Application Reference: 3/2024/1027

Site: KESTOR LANE RECREATION GROUND, PARK VIEW FLEET STREET, LONGRIDGE PR3 3ED

Proposal: Discharge of conditions 3 (construction method statement) and 4 (details of contractor's compound), 5 (ball strike assessment) and 6 (separation fence) from planning permission 3/2024/0656

Sport England Reference: P A / 2 4 / N W / R V / 6 9 5 2 1

**PUMP TRACK ADJACENT TO FOOTBALL PITCHES AT  
LONGRIDGE RECREATION GROUND  
FOOTBALL BALL STRIKE ASSESSMENT**

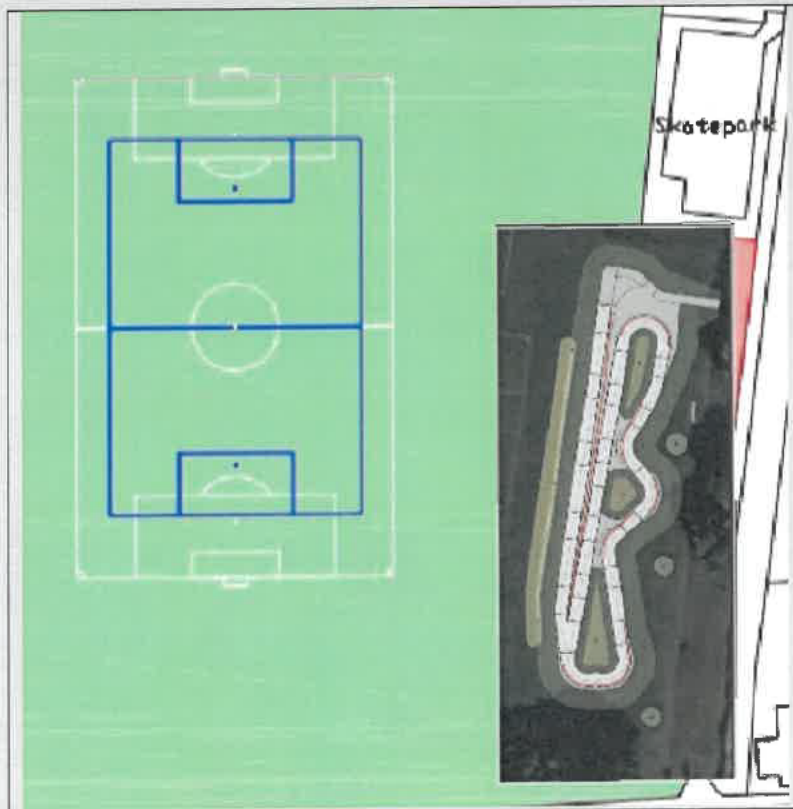
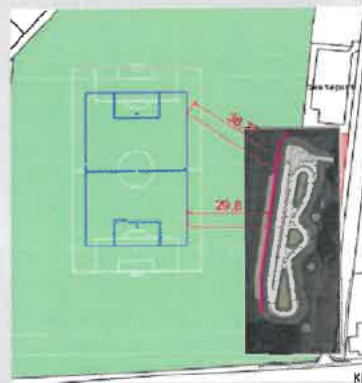
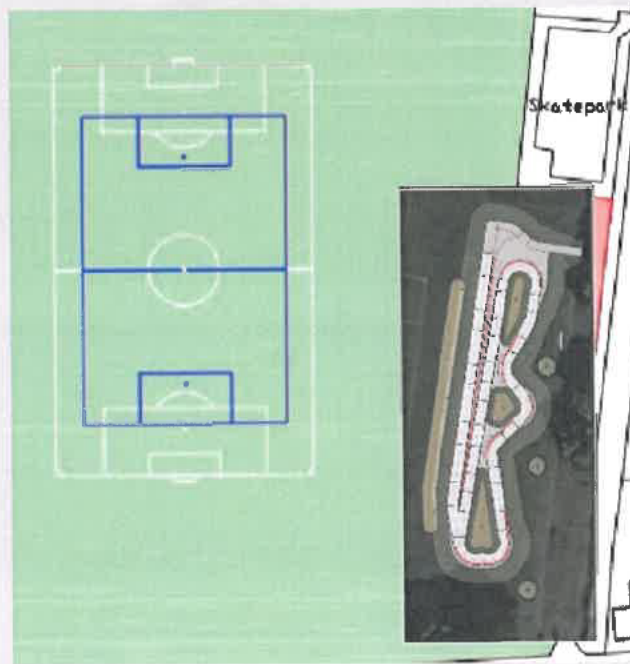
The ball trajectory assessment has been undertaken only on the basis of U11 use of the pitch area. The existing 9v9 pitch in its current position has sufficient space to be marked as a larger 11v11 pitch, able to accommodate U13-14 and U15-16 level play. Even with the pitch re-orientated as proposed, the ability to extend the playing area marked and used for older formats of play is still possible. Playing field is flexible space and should be used to adapt to the demands of the club and its uses. The ball trajectory model has not tested the prospect of ball trajectory risk from the likes of U15-16 11v11 play, or even adult 11v11 play which could be feasibly achieved in the space if the second pitch is proposed to be overmarked. This is evidenced by the previous pitch layout captured in the 2022 PP assessment, where the pitch was also previously marked north to south for adult football, before more recently in the last few seasons been reconfigured to reflect the needs of the user, which is for younger junior ages groups currently - https://pitchpower.org.uk/display/6692/DeSxbh1BluESUZgz-Zeu29m_gFQ/pdf/1.

However, it should be noted that this forms a delineation only and does not offer ball strike protection which as stated above, has not been tested to the satisfaction of Sport England and the Football Foundation.

TITLE  
 Post and Rail Fencing Specification

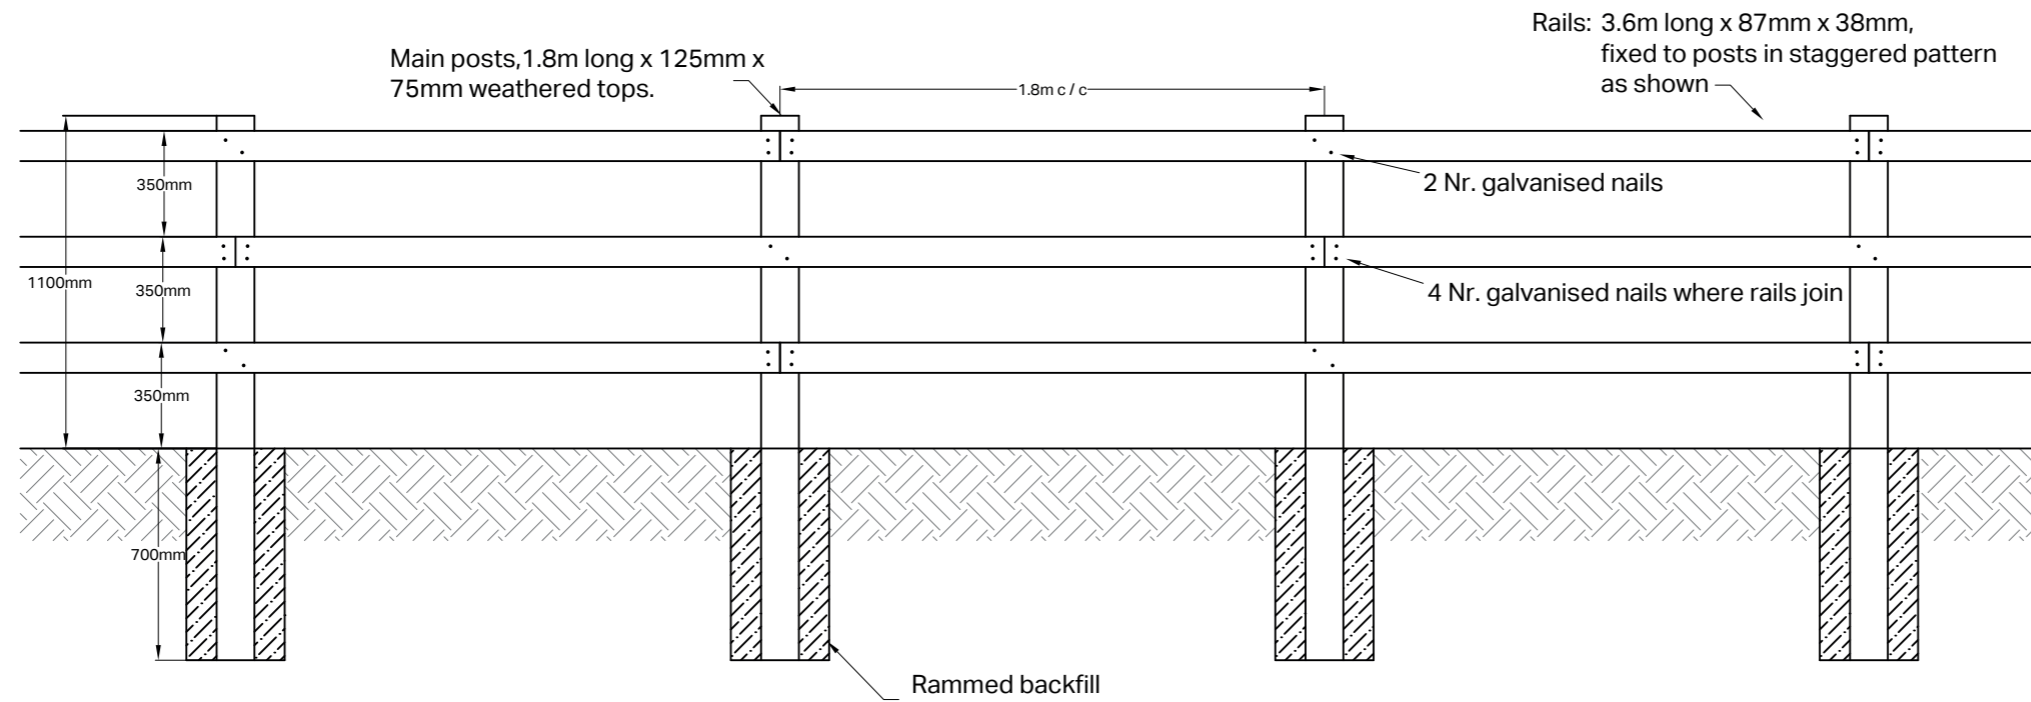
No objection to the submitted post and rail delineation fencing located at the edge of the pump track as shown on Drawings KLN90_1 Rev 1 and KLN08_3 Rev 3 which is sufficient to discharge the submission element of condition 6.
